# Item 6

**Ref: 2019/0623**

Description: Residential development of 97 no. dwellinghouses with garages, parking spaces and public open space and associated roads and sewers.

Lowfield Road, Bolton Upon Dearne

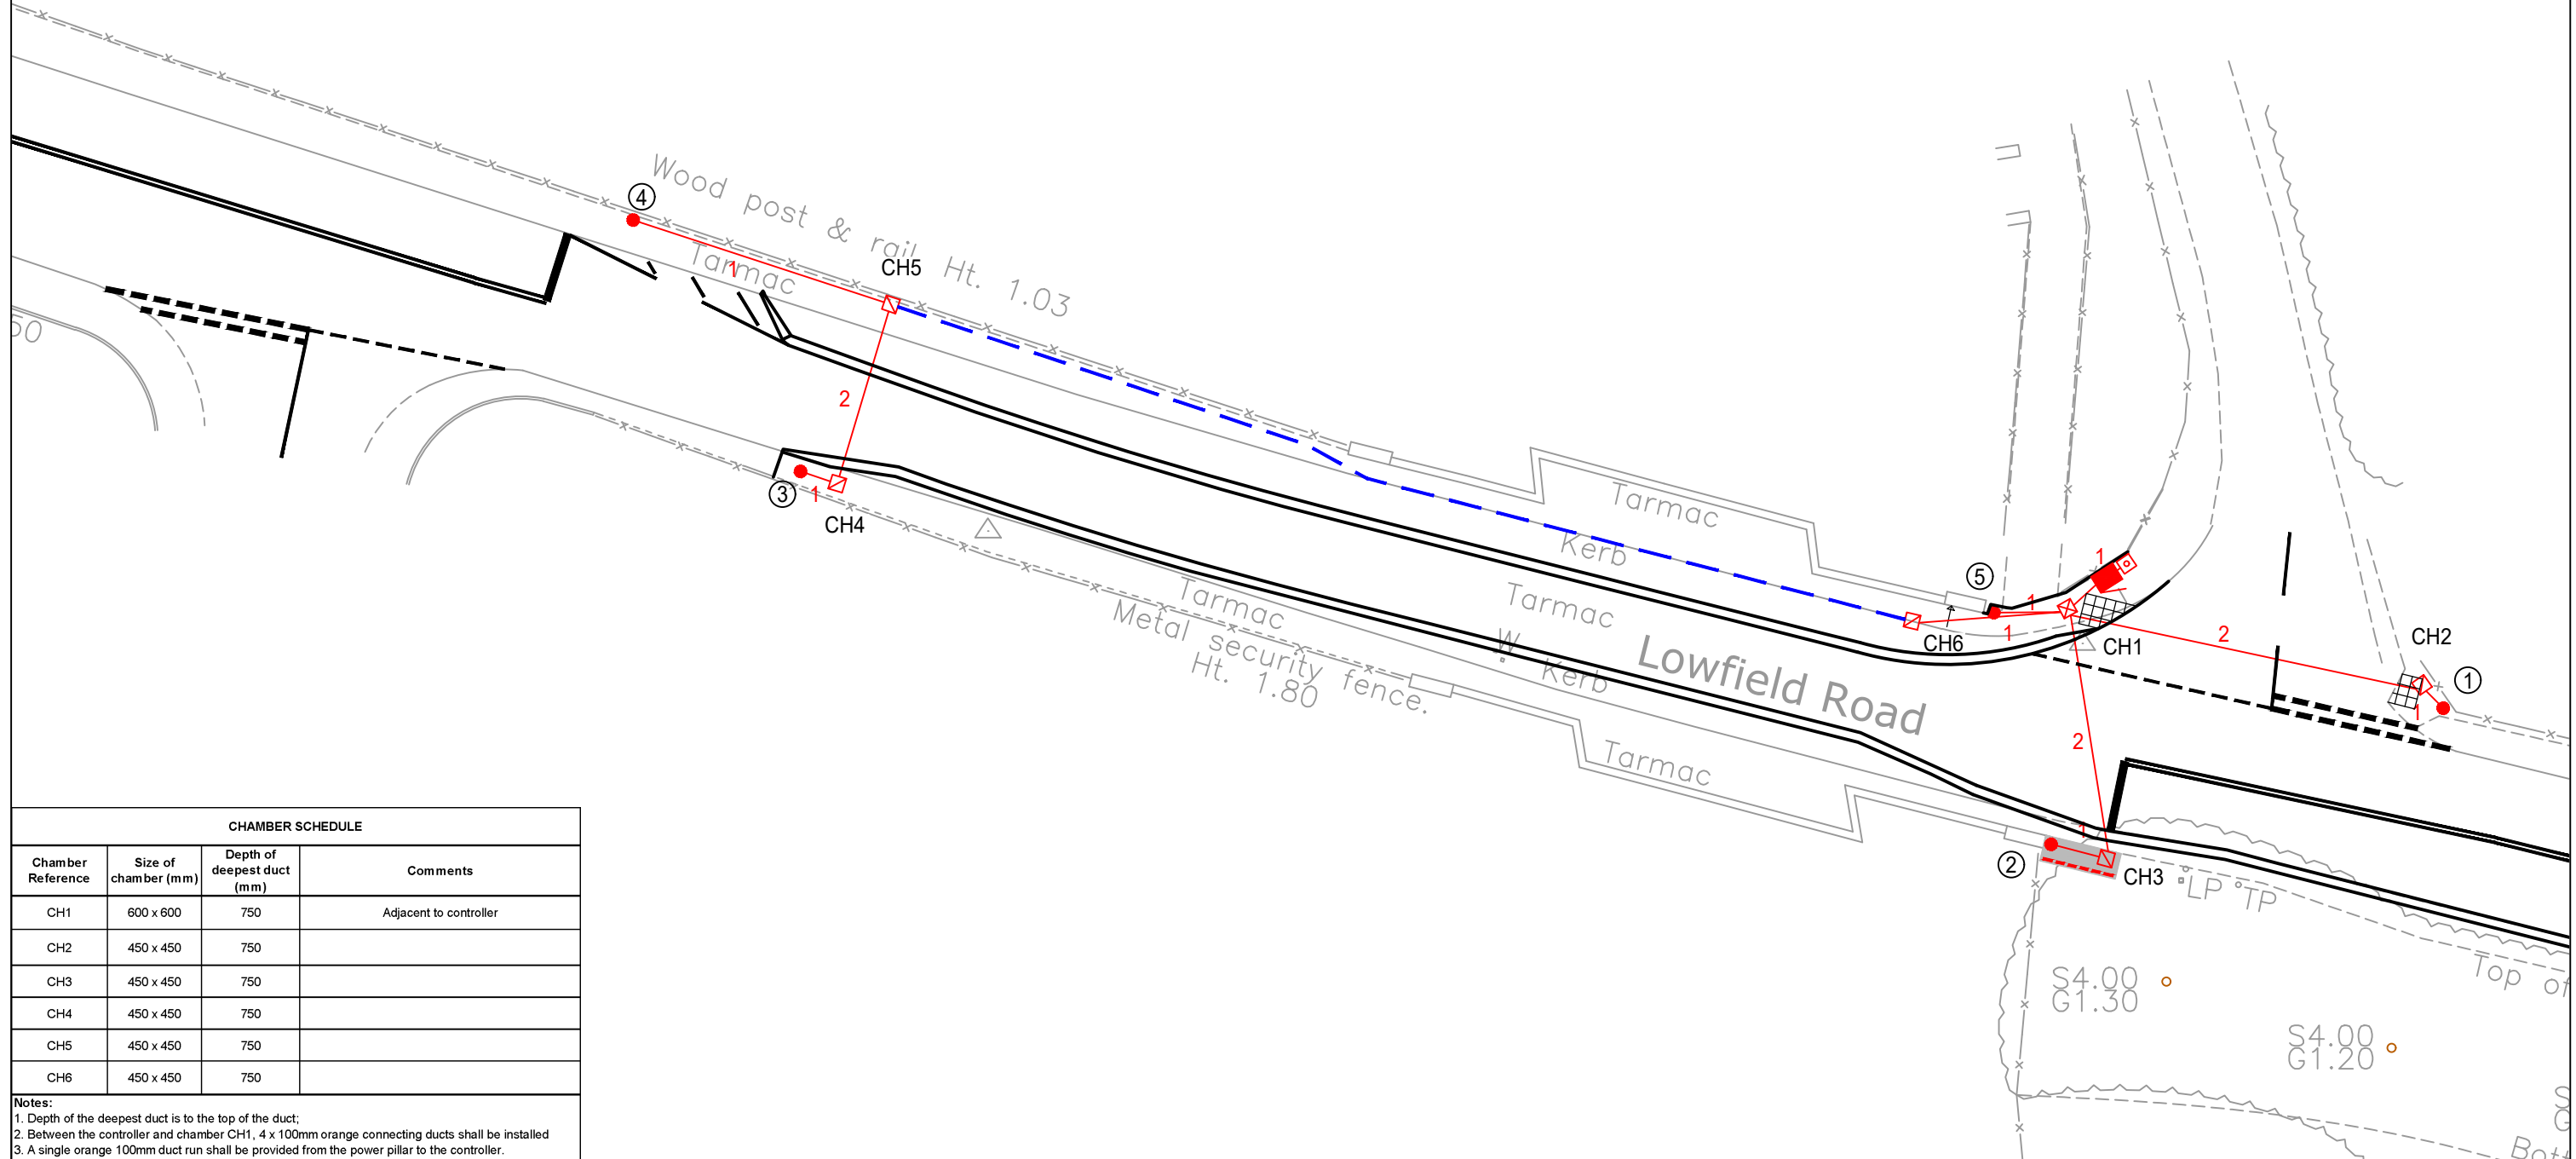
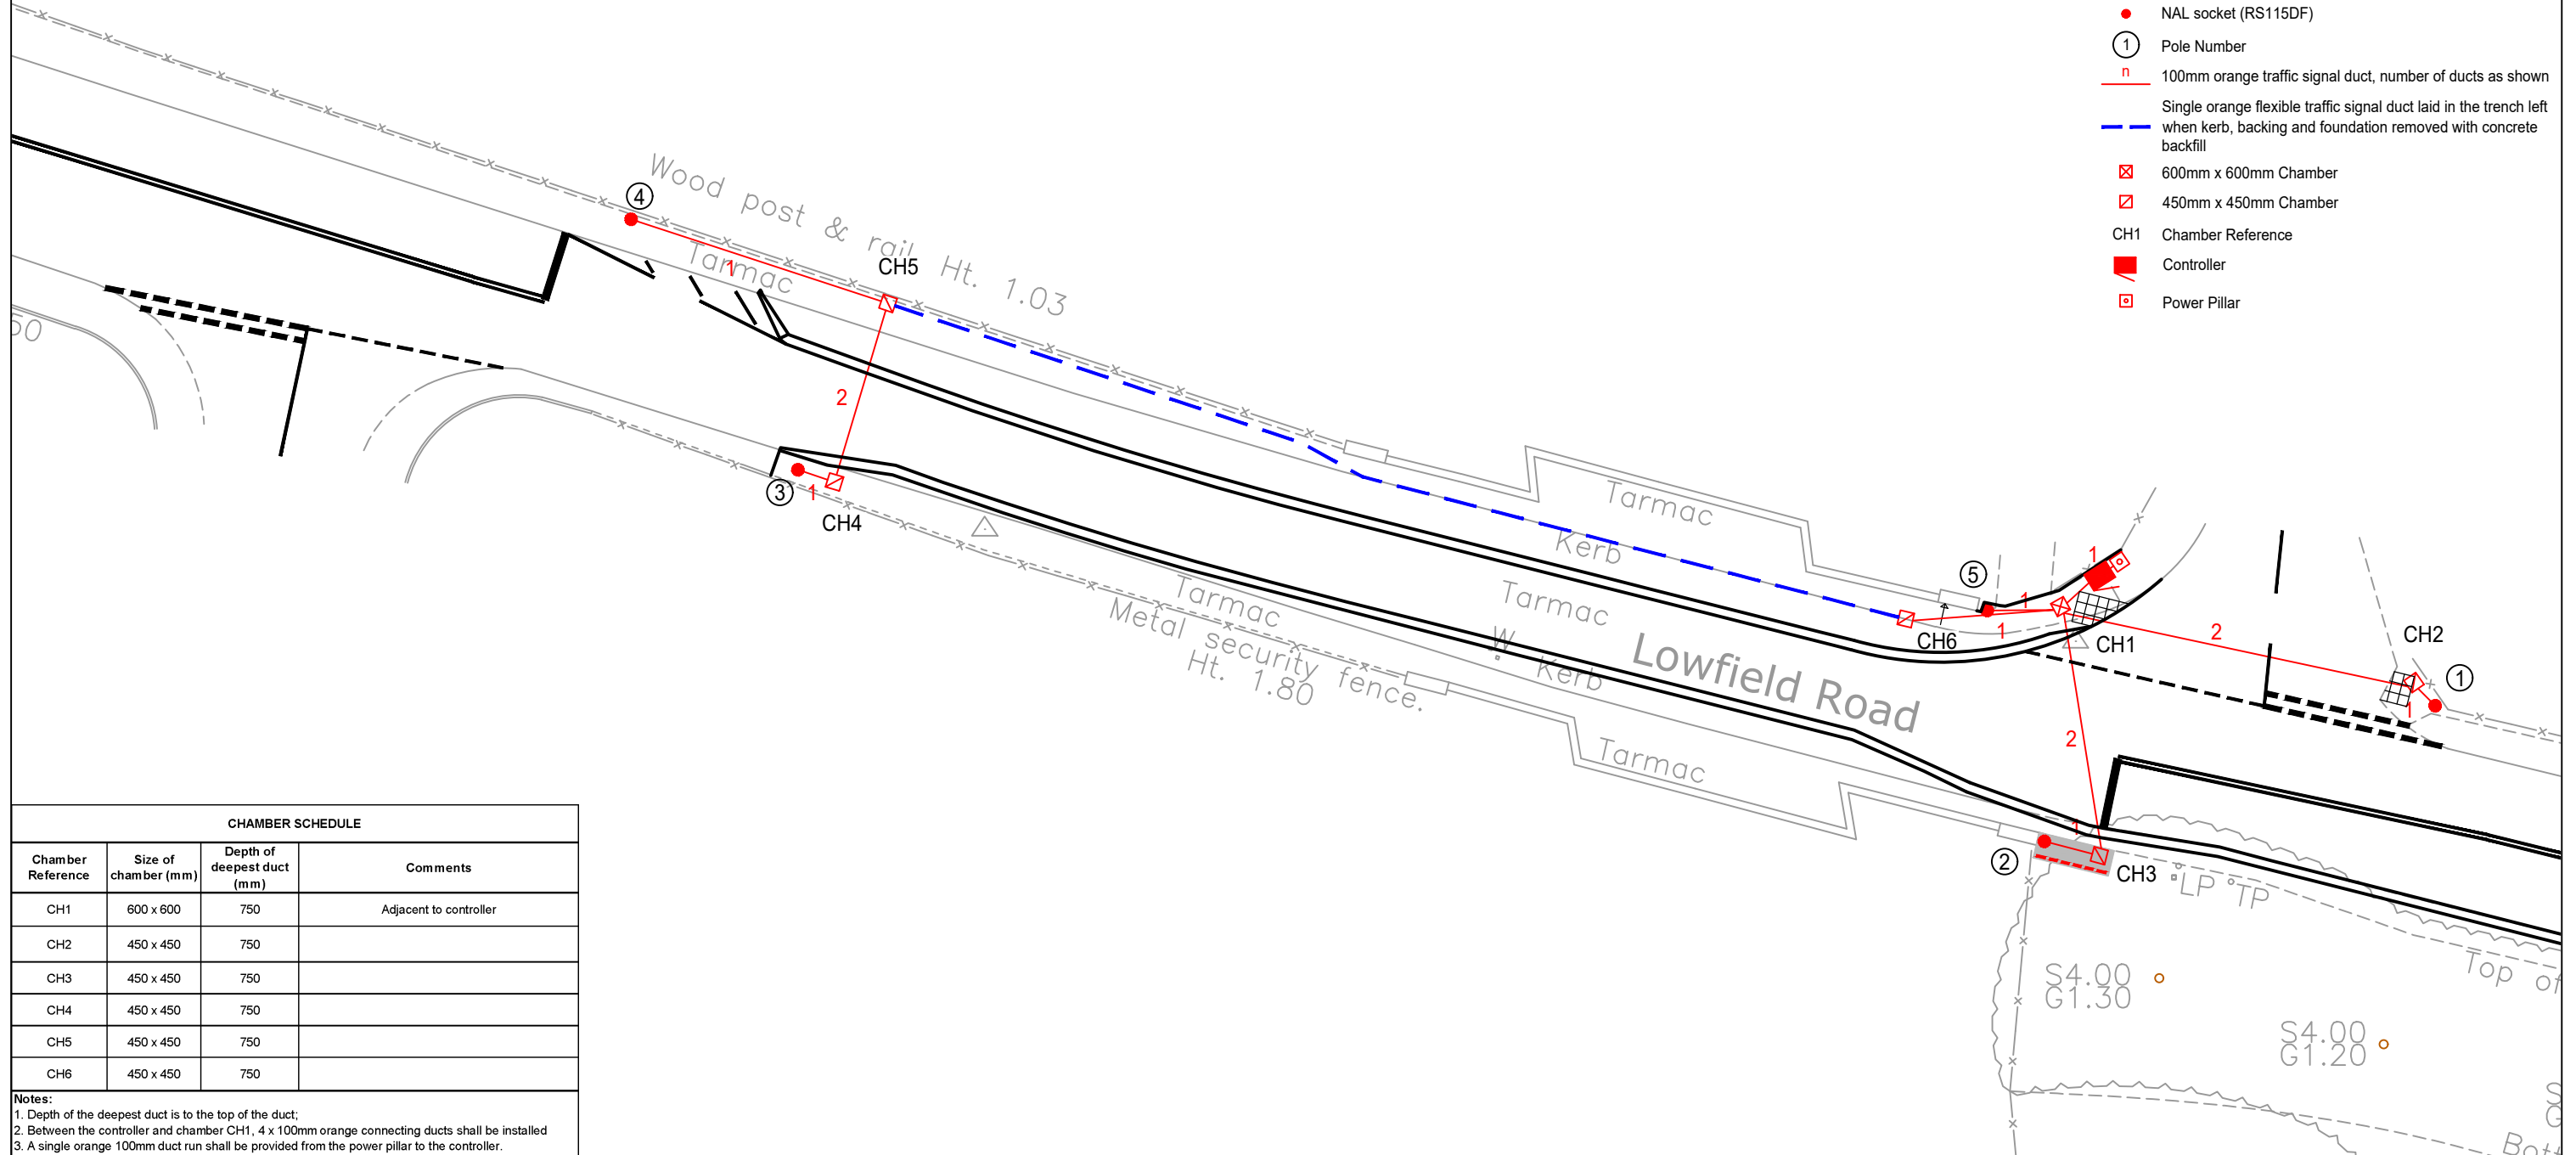
The latest design submitted by the applicant proposes to introduce a new traffic signal installation that is a resubmission of a solution rejected by Highways on previous phases of the development

site. It essentially seeks to provide a traffic signal and stop line at both east and west approaches of Lowfield Road

From a feasibility perspective, the main issue is the allowance for the side road on the east side approach. The swept path analysis submitted with the application does not demonstrate that all manoeuvres (entering and exiting the public highway) can be safely undertaken, resulting in vehicles overhanging the highway or centre line. Under the current highway operation, a vehicle can exit the access uncontrolled under the give way conditions and join the highway. However, the proposed mitigation and new traffic signal operation does not permit an appropriate vehicle to complete the manoeuvre and wait in the relevant position (i.e. before the stop line). This, coupled with the potential for vehicles approaching from the west to do so on a green signal, with an inference of comfort that the way ahead is free from obstruction, is the primary reason why the proposals are considered to increase the risk of collision and injury to users of the public highway and cannot be supported in their current form.

Furthermore, from a buildability and maintenance perspective, the Council also has a duty of care to its operatives on the public highway network. Within the current proposals, the positions of the traffic signal controller and signal poles are deemed to be located in such a way to prevent them being maintained safely without possible significant civil engineering works.

For the reasons above, as the proposals currently stand, they are unacceptable from a highways perspective as they are contrary to policies T4 and HS42 of the Barnsley Local Plan and, are detrimental to highway safety and efficiency, contrary to NPPF (July 2021) paragraph 111.
